Planning Application Ref: **AW/346/18/T**

Location: **36 Kingsway and 41 The Drive, Aldwick**

Description of works: **Crown reduction of 2 - 2.5m to 1 No. Oak tree. Crown lift of 3m to 1 No. Oak tree**

41 THE DRIVE IMAGE SHEET 1

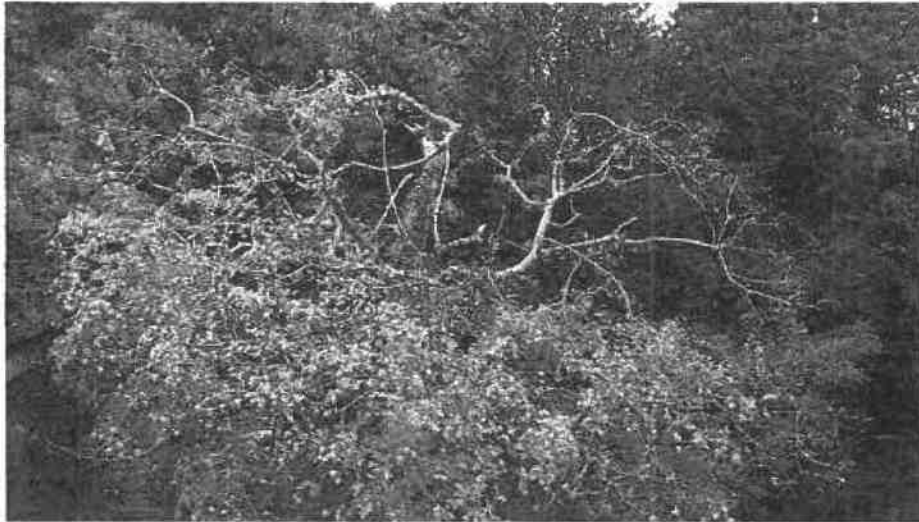
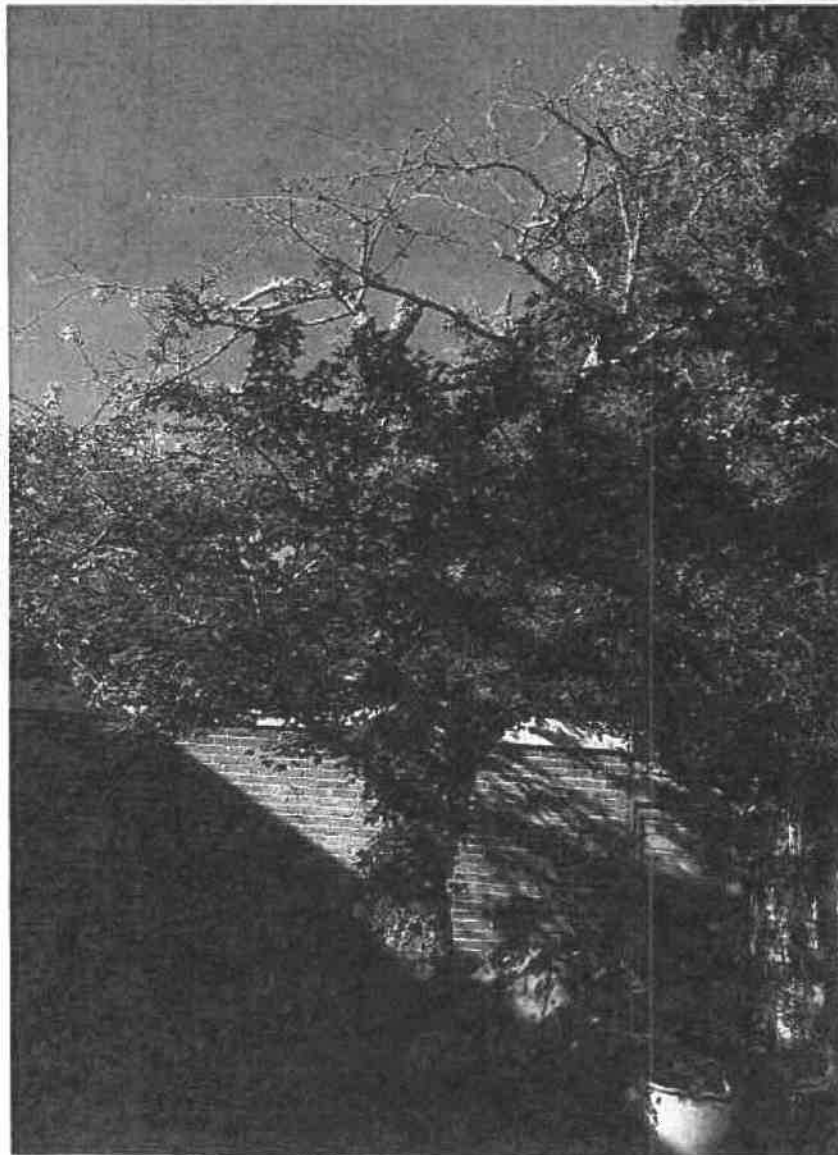
- Outwardly and from a distance both trees appear to be in a fine physiological state.
- They grow alongside and to the rear of property and can be seen from neighbouring dwellings. They are visible in part to traffic and contribute to the high canopy locally for which this area is recognised.

- If the work is undertaken to a good standard and at the right time; then it is unlikely to have an adverse effect on the tree's long-term vitality and visual amenity.

- Where whole branches are to be removed and final cuts made close to the trunk or branch union they are to be made as shown in Figure 2 of BS3998:2010
- Where branches are to be shortened back the final cuts are to be made at the correct angle shown in BS3998:2010 and adjacent to a live bud or lateral.
- The removal of crown material which has developed since the last operation (ref.C) must be done sympathetically and with respect to established 'knuckles' so as not to extend beyond the point of origin.
- The long-term vitality of this tree (ref.C) is best respected when significant pruning work such as proposed, is undertaken during either the late-spring to summer (May to August) or mid-winter (January to mid-February) periods.
